**Cheshire West and Chester Council's Representation Made at  
Deadline 8**

**Submitted at Deadline 8 – 12 September 2023**

- 1.1. Cheshire West and Chester Council (**the Council**) is one of the host authorities for the for the Liverpool Bay CCS Limited's (**the Applicant**) HyNet Carbon Dioxide Pipeline DCO project (**the Project**)
- 1.2. This document is the Council's Written Representations, submitted at Deadline 8 of the Examination into the DCO.

DRAWING TITLE  
Figure17.7: Road Diversions  
Sheet 1 of 8

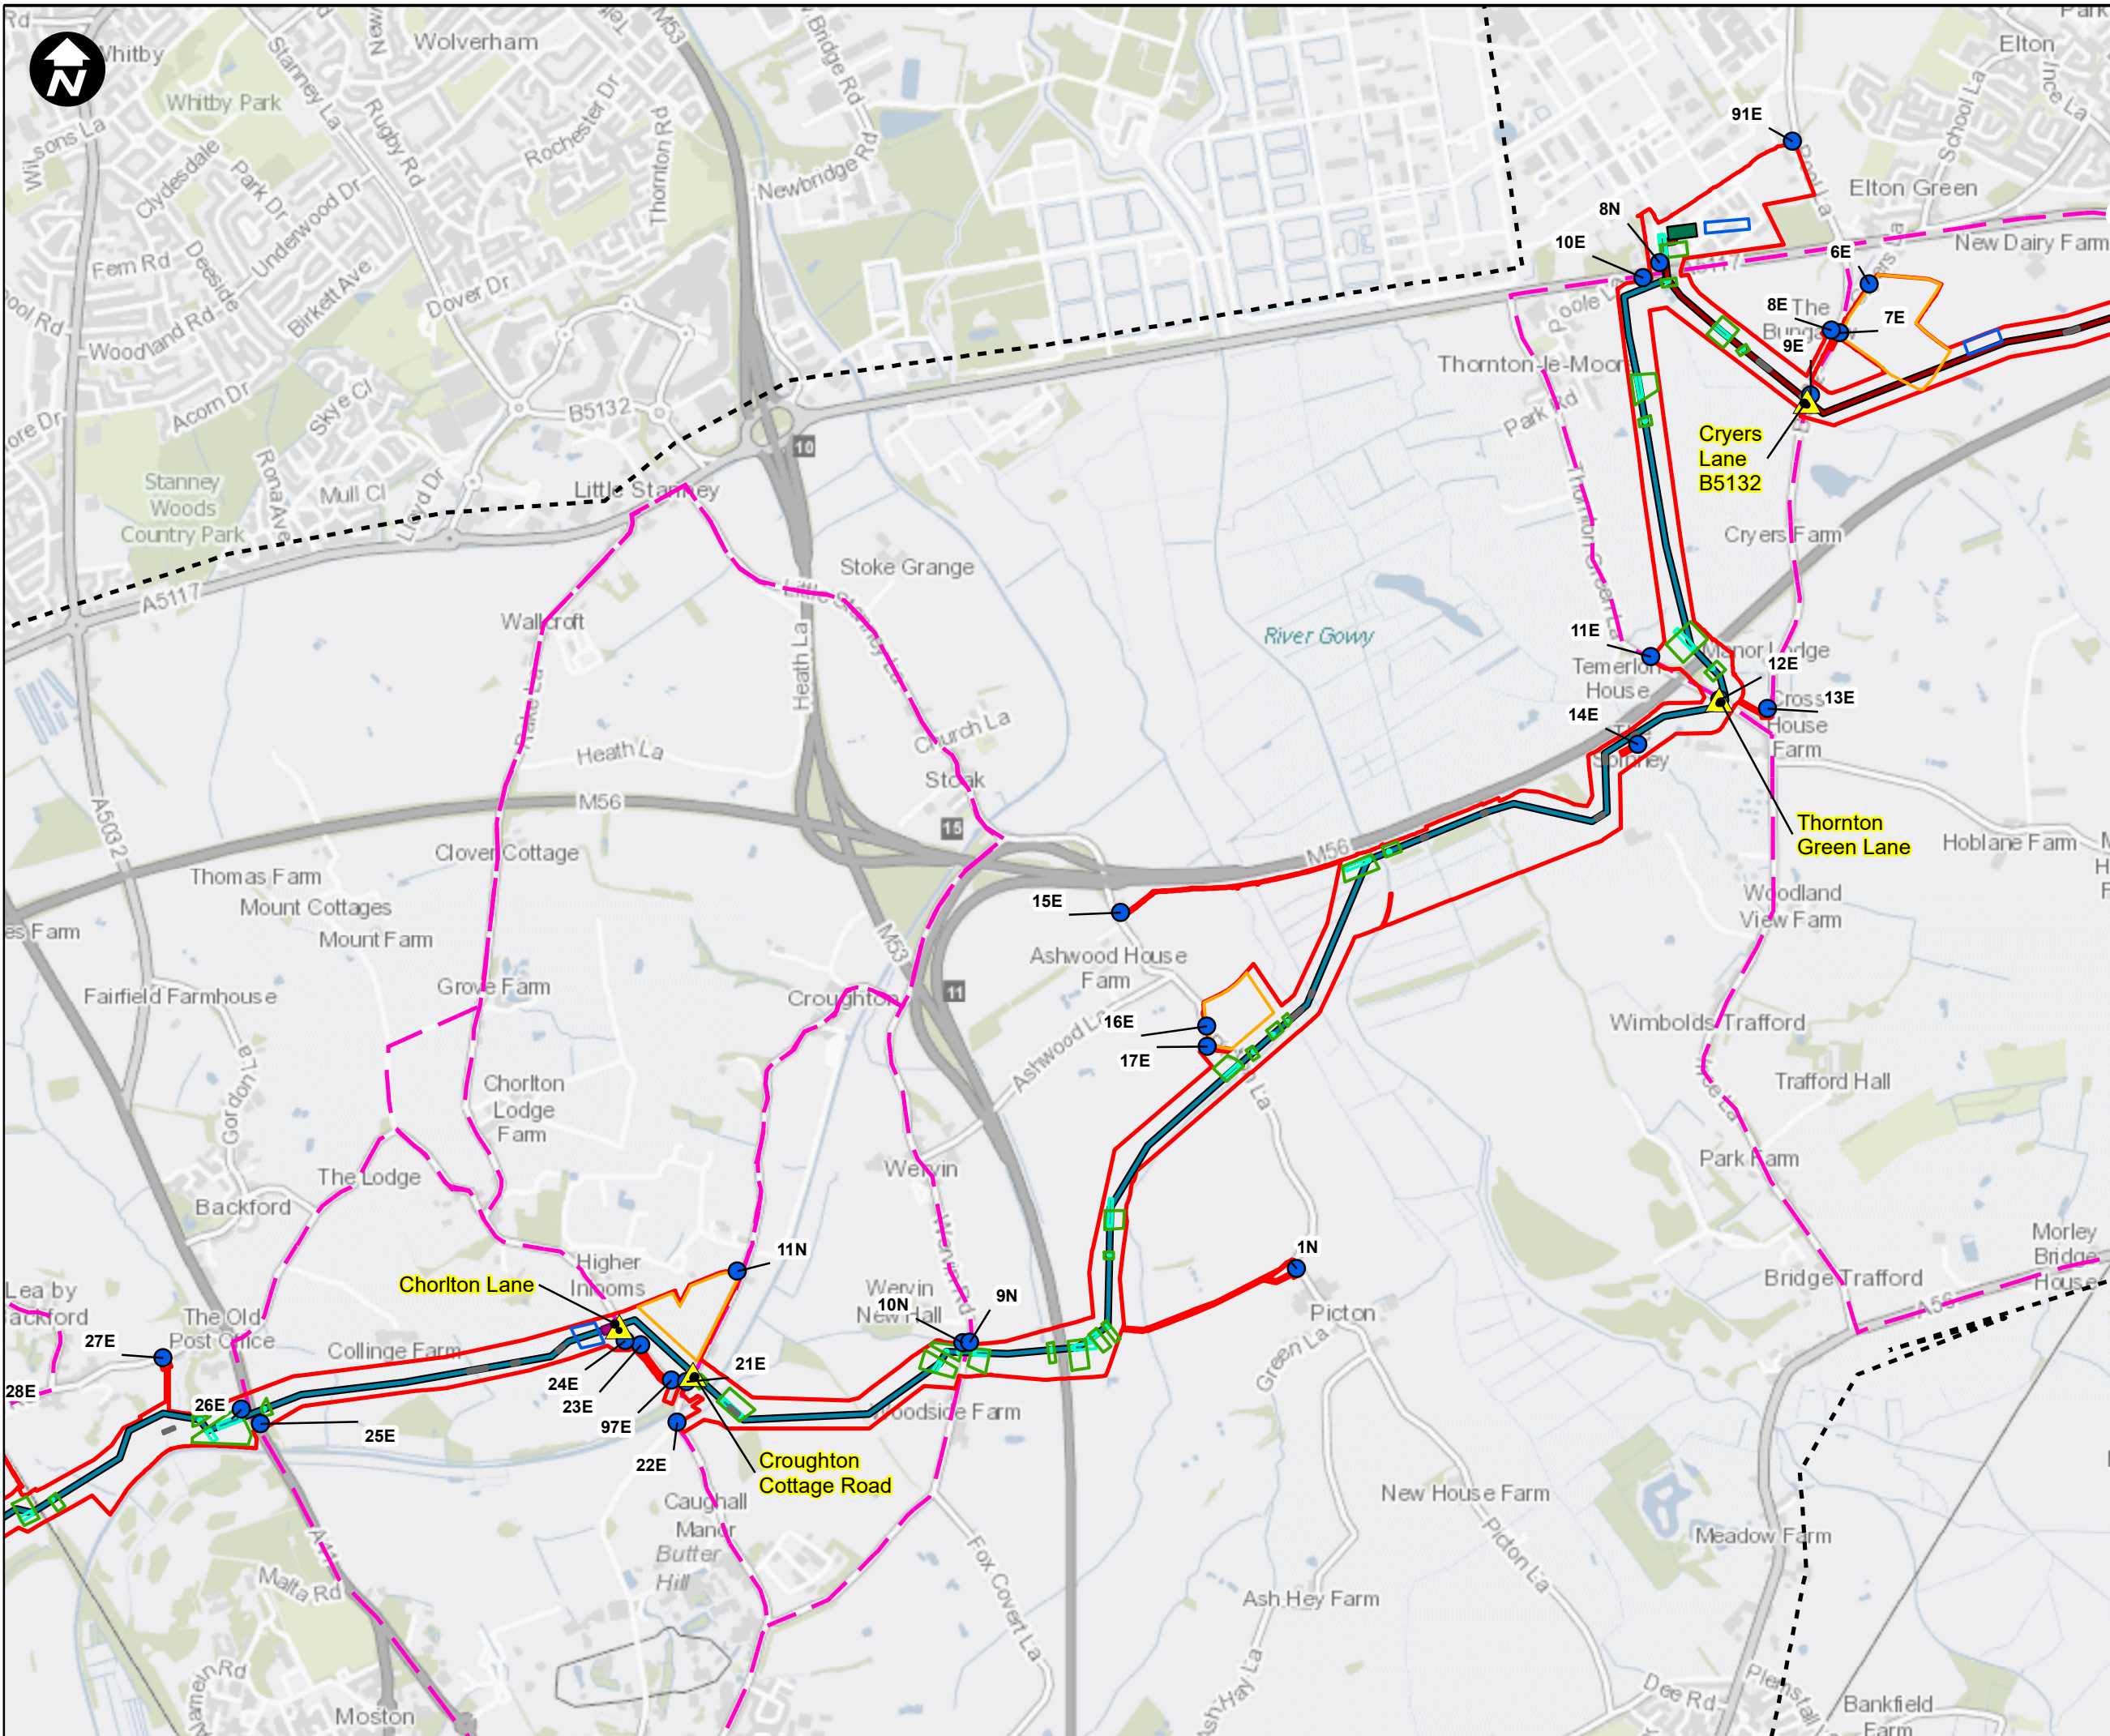
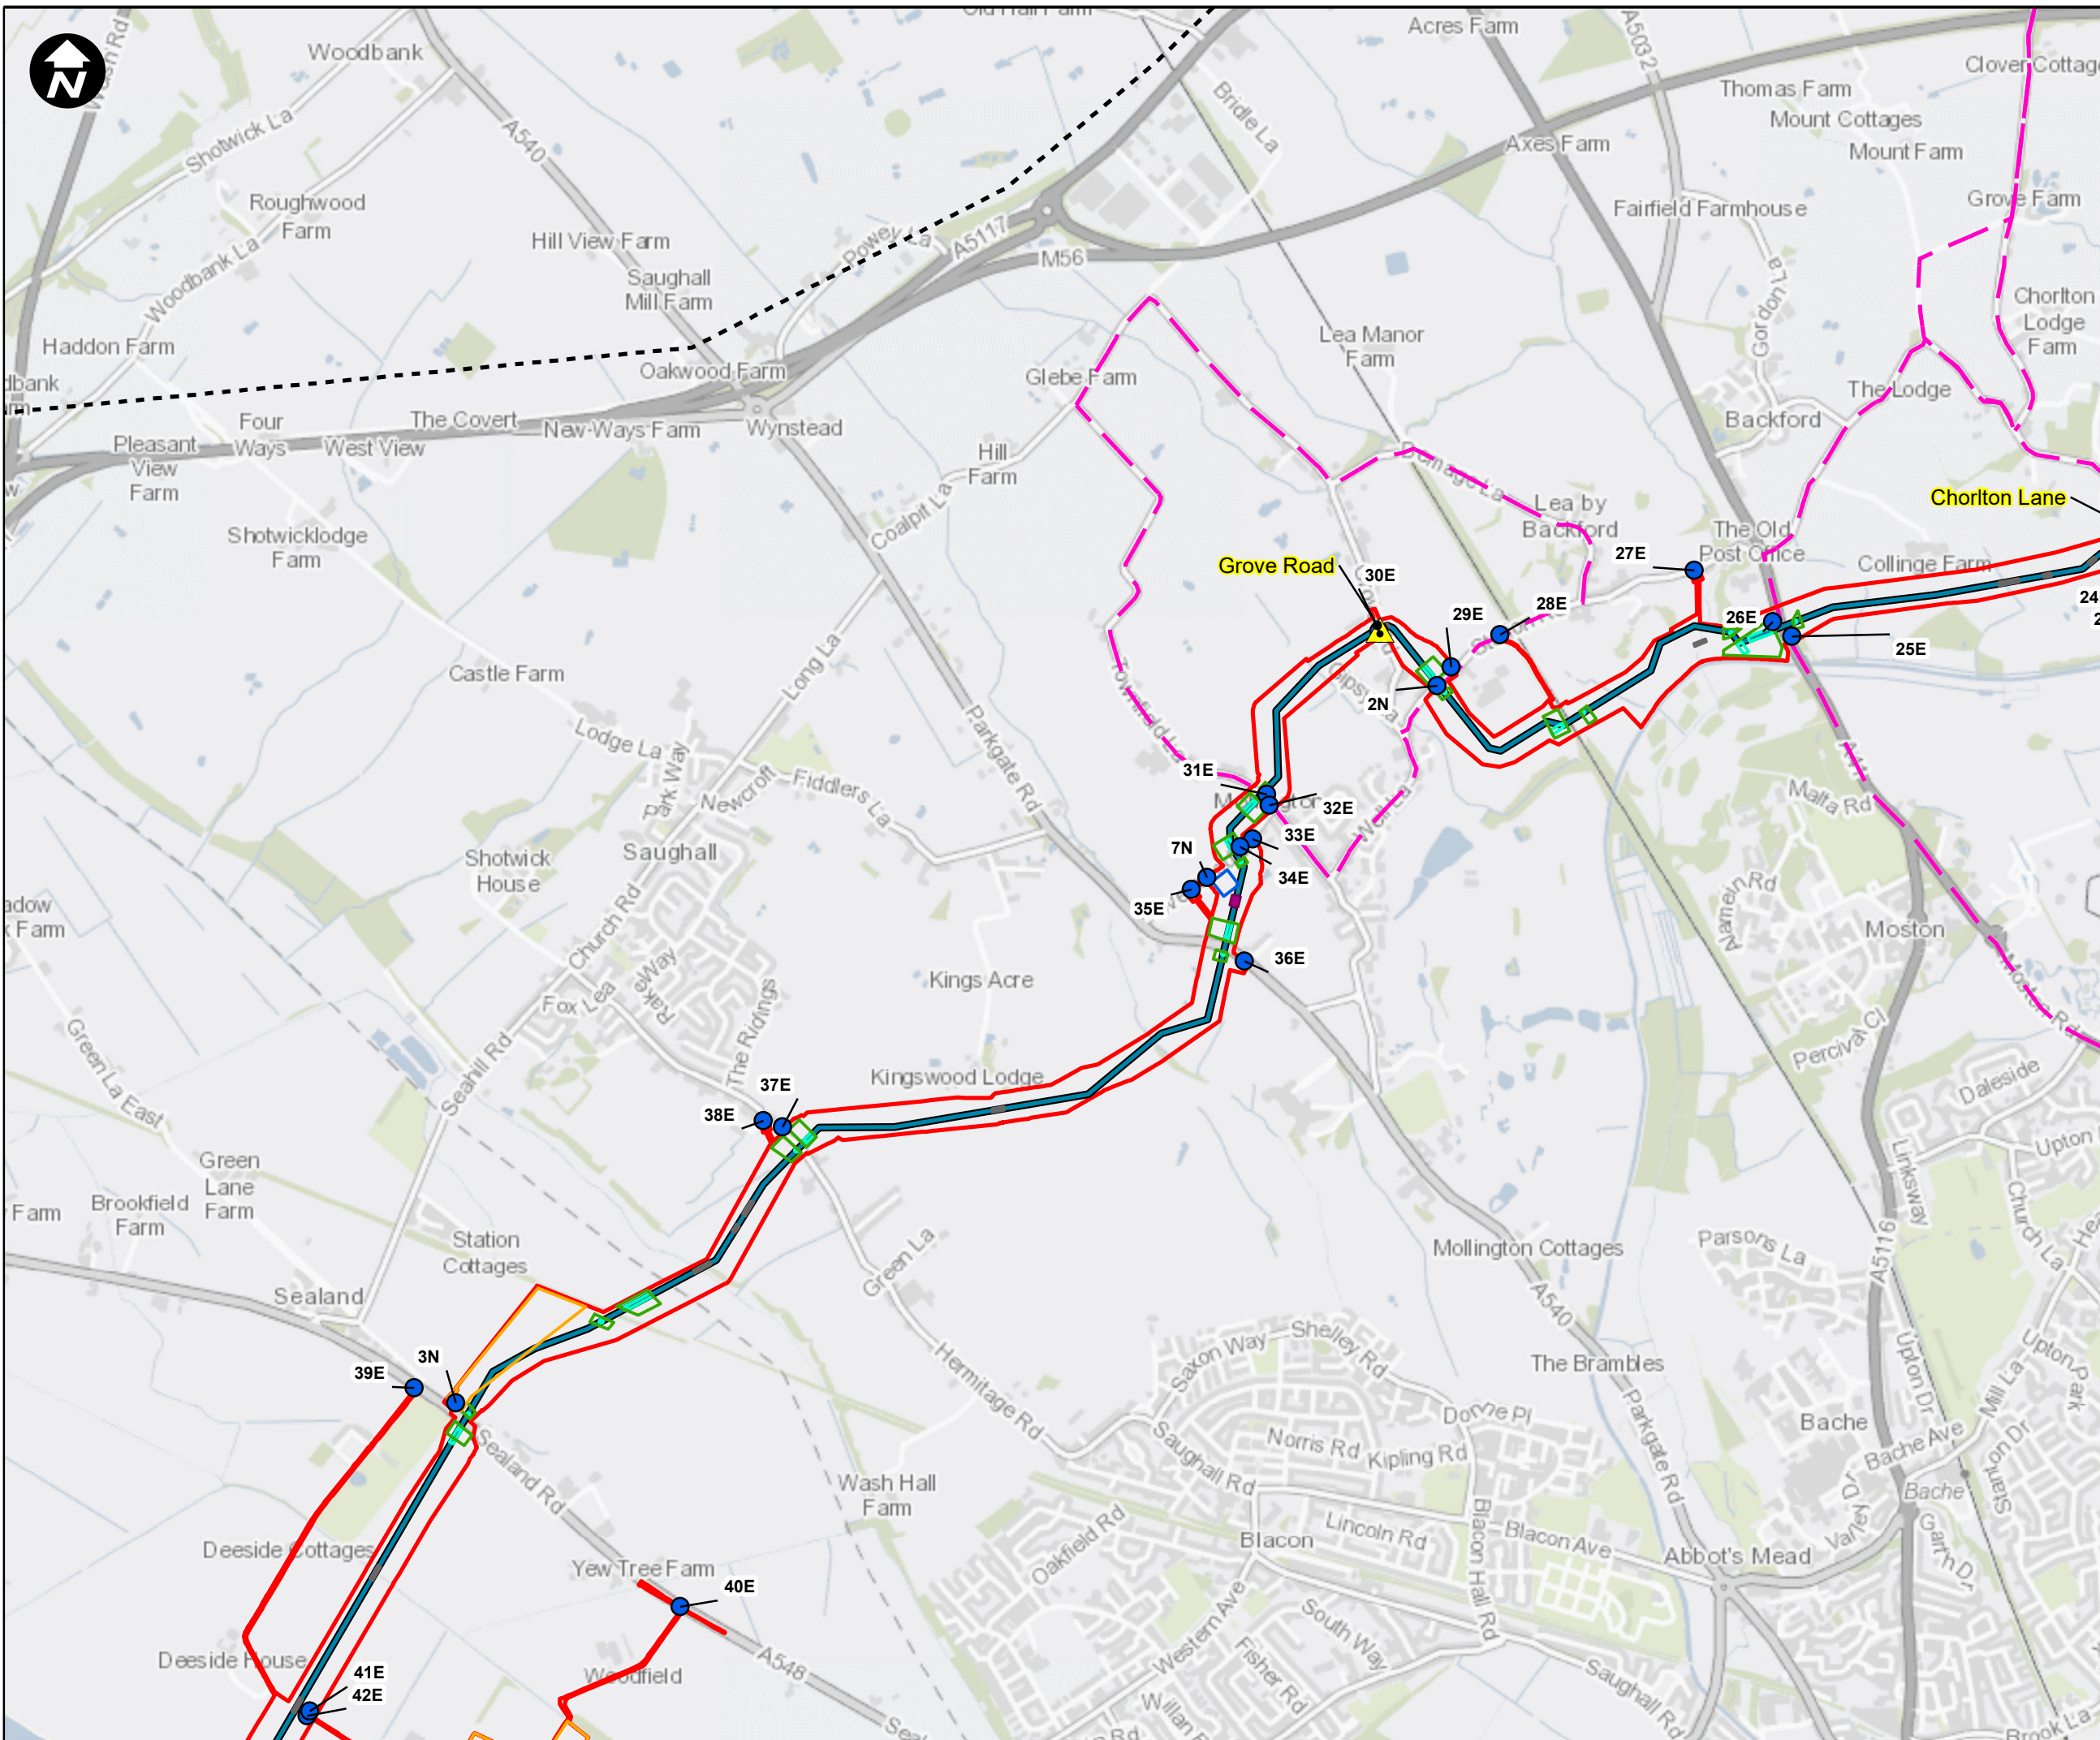
Paragraph	Text	The Councils Response
5.5.3	These are presented in <b>Figure 17-7 - Road Diversions (Volume IV of the ES) [CR1-095]</b> .	The Council notes that the diversion routes included have not been indexed and is not clear which route is used for which closure.

7.3.4	The following mitigation is proposed:  <ul style="list-style-type: none"> <li>• During the Construction Stage, advanced warning signage will be implemented to slow vehicle speeds on approach to construction accesses and warn other road users of site traffic</li> <li>• Provision of Manual for Streets (MfS) compliant visibility splays with associated verge trimming and clearance; and</li> <li>• It is recommended that 'Slow' road markings on the eastbound approach to the permanent access location to reduce 85th percentile speeds are implemented for the operation and maintenance stage of the DCO Proposed Development.</li> </ul>	The Council notes that the CC CTR 2 and BVS CTR 1 routes are incorrect and they do not account for one-way systems, hence the Council requiring detailed diversion route indexed per closure/works location.
